Application for a Non-Material Amendment Following a Grant of Planning Permission

Two storey extension to the rear of the property, single storey extension with a single storey porch to the front elevation.

S.23/0043/HHOLD

Removal of the gable and replacement with a flat roof, together with an increase to the front porch by 50cm.

Drawing Number
01 Minor Amend

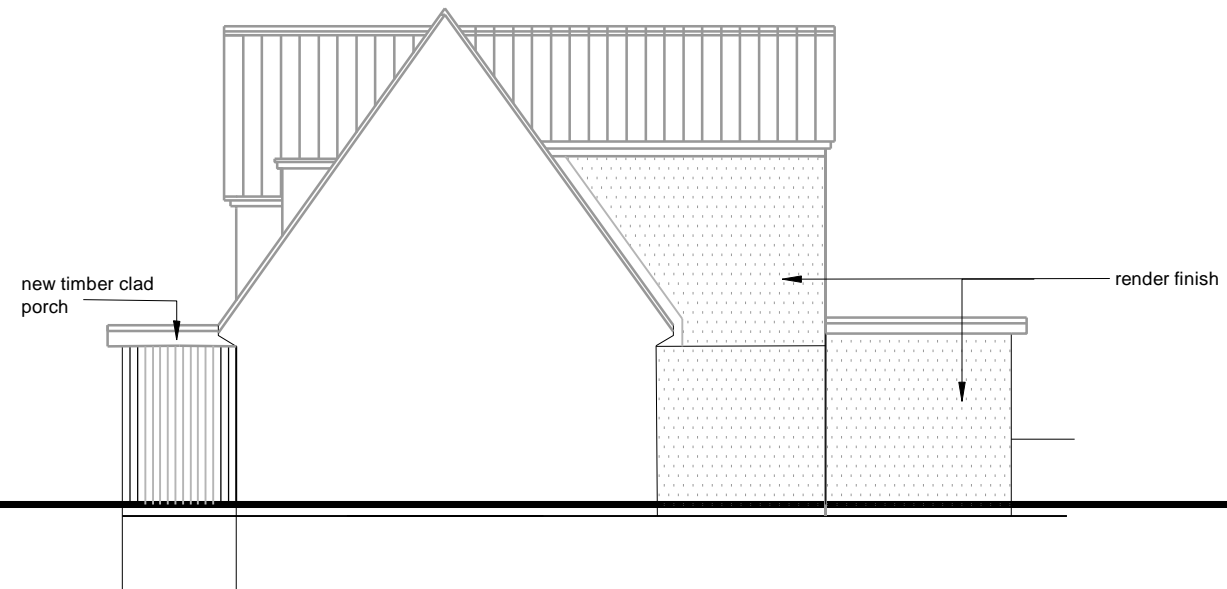
1: A flat roof to the rear of the property.

The rear of our property is where the extension will be located, and passers by will only be afforded a glimpse of the house and extension. It should also be noted that throughout most of the year there are dense shrubs along the road side garden boundary which obscures the view almost in its entirety. Furthermore, the refusal for a flat roof has left us with a new design of a gable, the build of which will incur unnecessary additional material costs and labour. When taking these factors into consideration and due to the added complexities put upon us by the Council, this scheme becomes overall cost prohibitive.

2: Increase in porch width by 50cm

The purpose of the porch is to enable a practical storage of coats, boots and alike to support village country living with a busy family and pets. The previous comments made by the planning team to reduce the width of the porch, provided no reasoning or suggested dimensions. Within the approved scheme the porch is narrower than required. It can be observed in the attached elevations that the porch being in line with the gable produces, we feel, a very satisfying aesthetic appearance of clean lines. The increase in width is minimal at 50cm, yet will provide us with the required practical space.
